4th April 2013

Dear Ms Osland,

Re: BR 70/13 Application for erection of new detached garage. 178 Hawthorn Rd, Bognor Regis

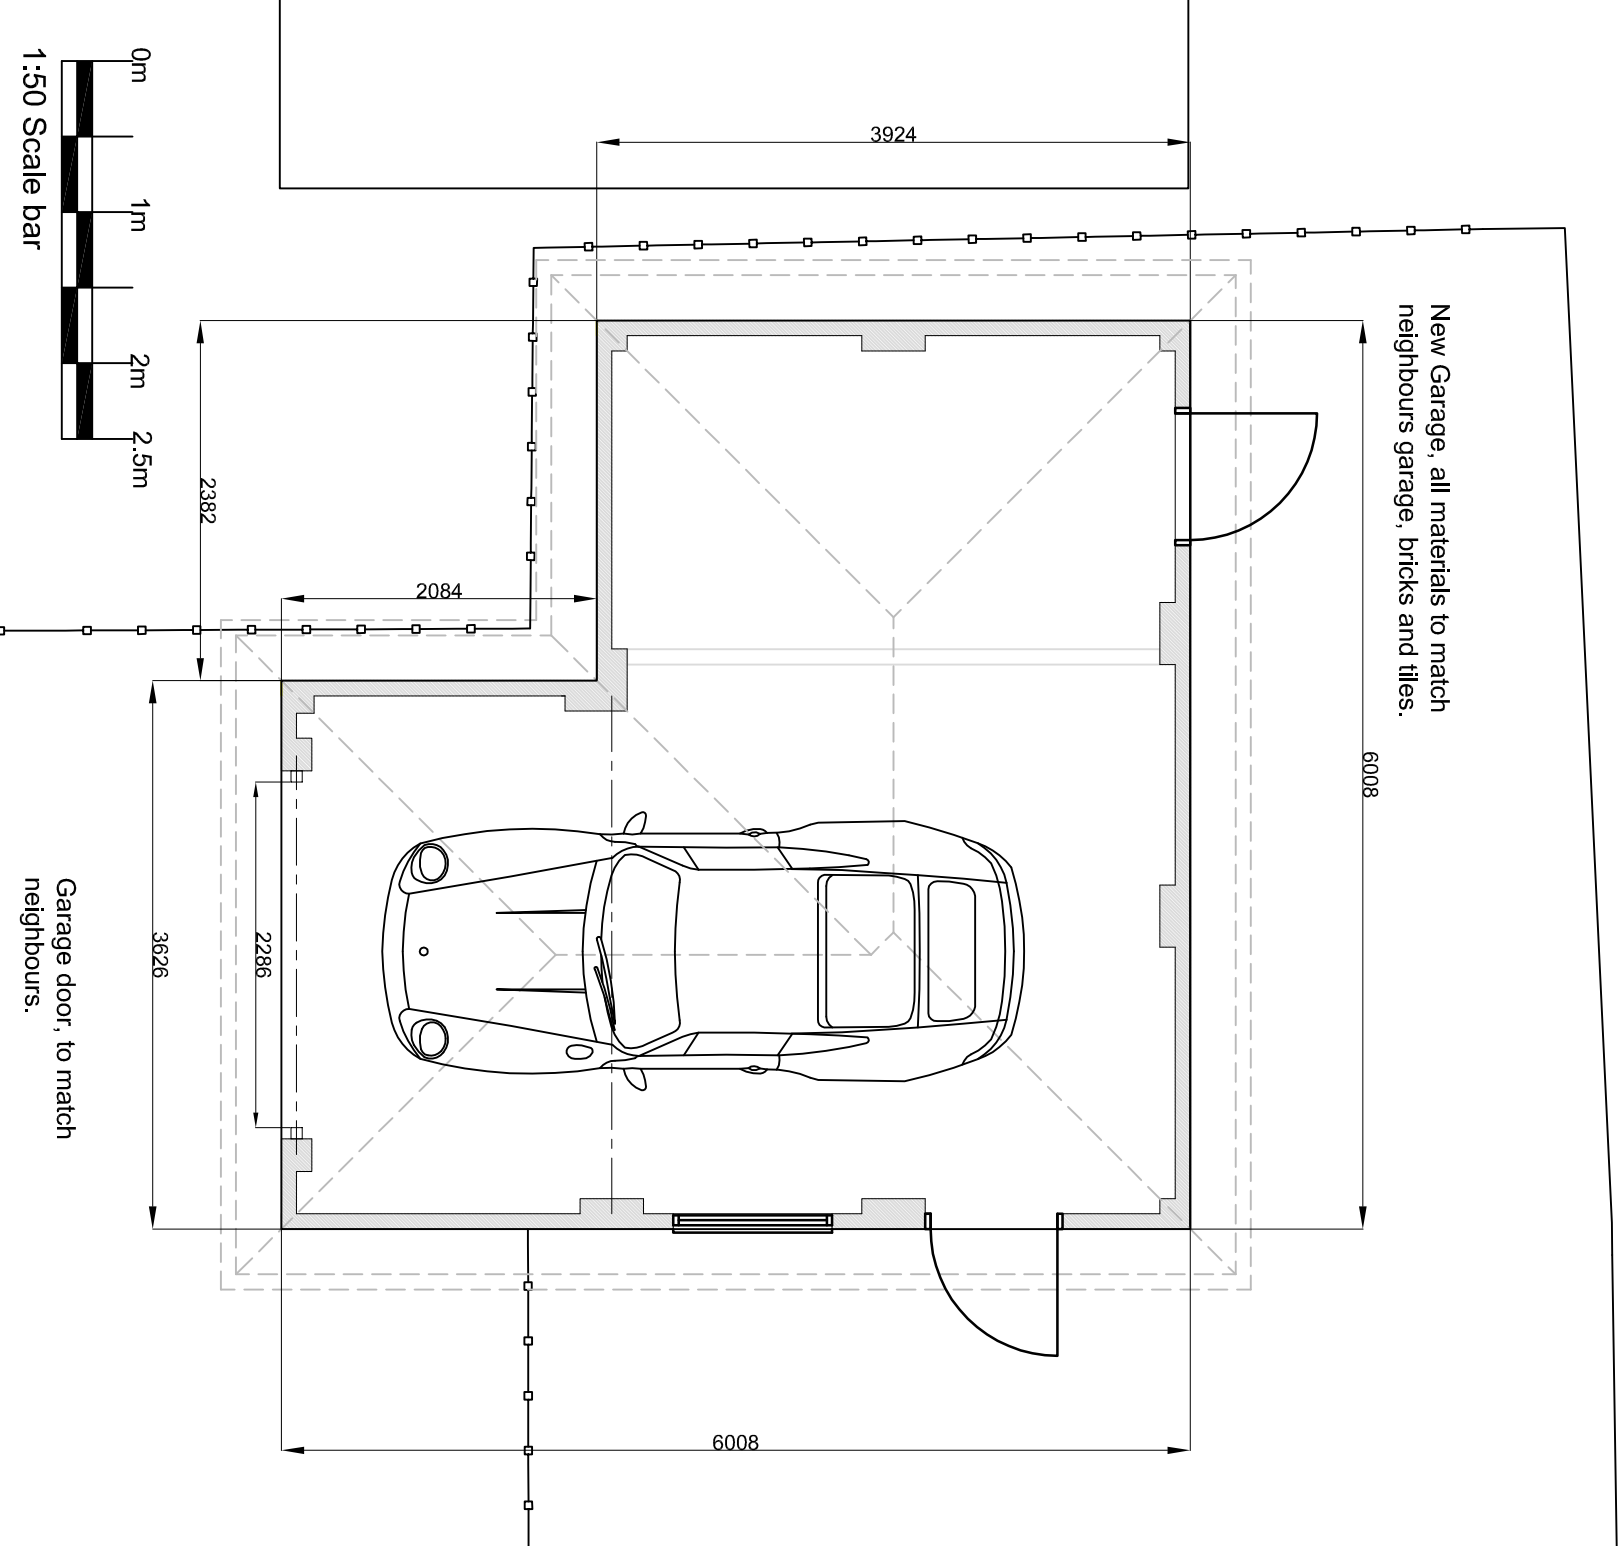
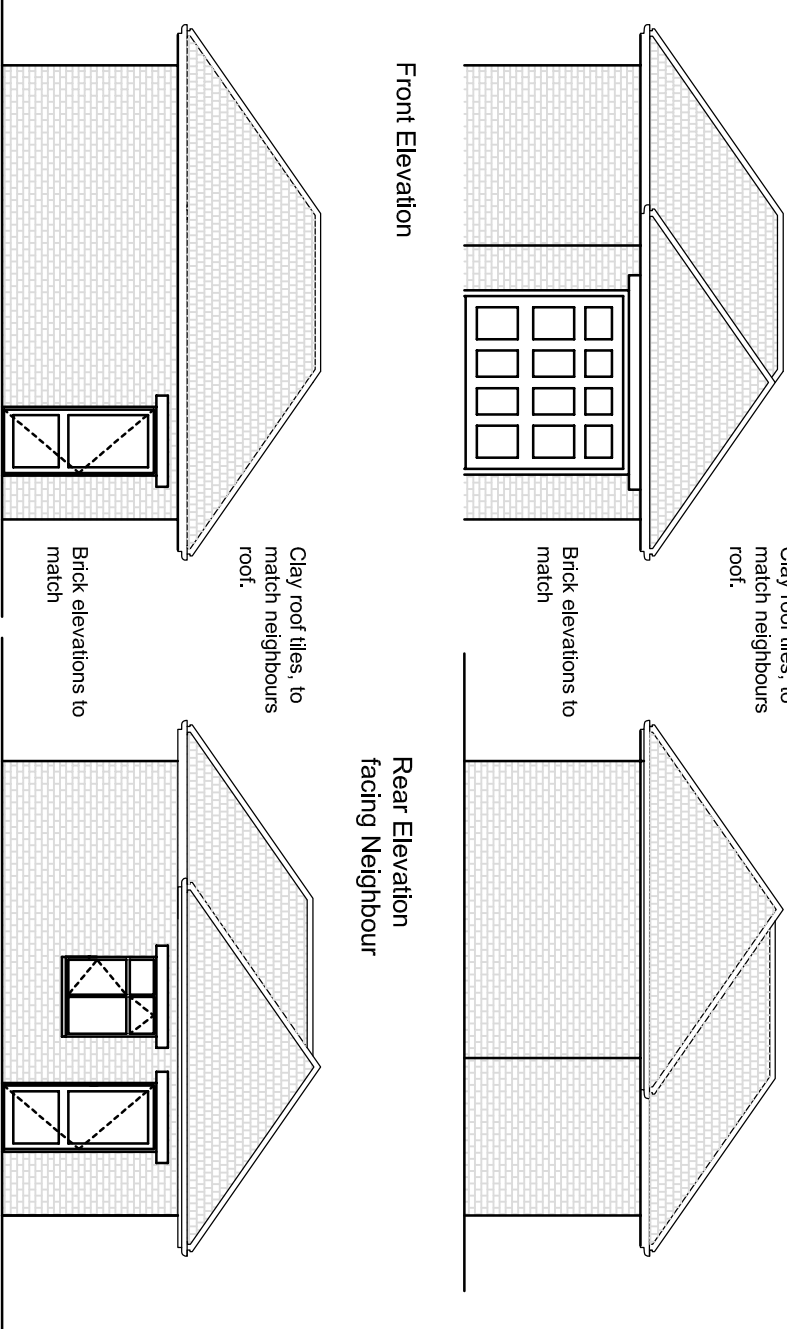
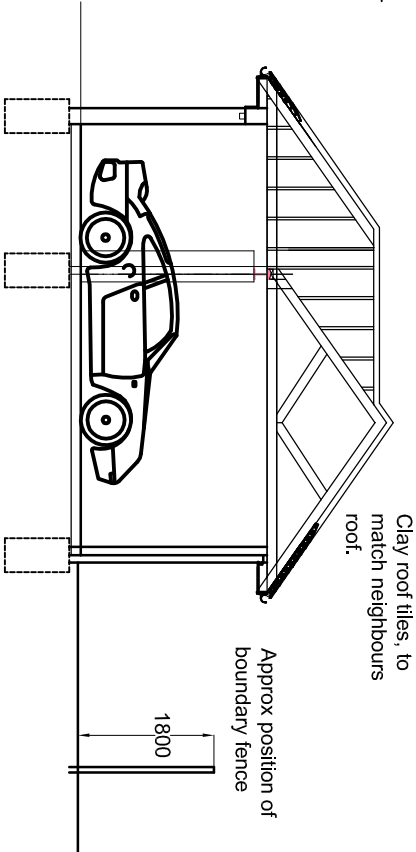
You will see from the original plans attached (**1**) that this garage measured 3.2 metres x 3.2 metres. The proposed measurement of Mr & Mrs Hartley's garage is to be 6 metres x 6 metres at its longest sides but is portrayed to be of similar size on the location plan (**2**) to the garage behind. This is clearly misleading to the Committee, as is the obvious omission of the proposed height of the building, which also is to be as high as the garage behind it. The applicant's agent has provided a photo to give the impression that the development will look just like the garage 'next door' which, of course, it won't (**3**). This, again, is misleading to the Committee. We feel that the overbearing nature of the proposed building will therefore be unacceptable .

You may also understand our concerns that this is to remain as a garage, in view of what happened with the garage at 178a. The proposed development has 2 entrance doors, windows and the normal drive in garage door. It's large enough for a potential dwelling.

The Hartley's are a nice family and clearly need a garage for normal storage purposes . We would have no objection to one of a size appropriate to the land and at least considerably lower than the proposal. We would suggest a height similar to the top of our blue shed (which is coming down later this year), and we would also request restrictions on future change of use or alterations to shape or size.
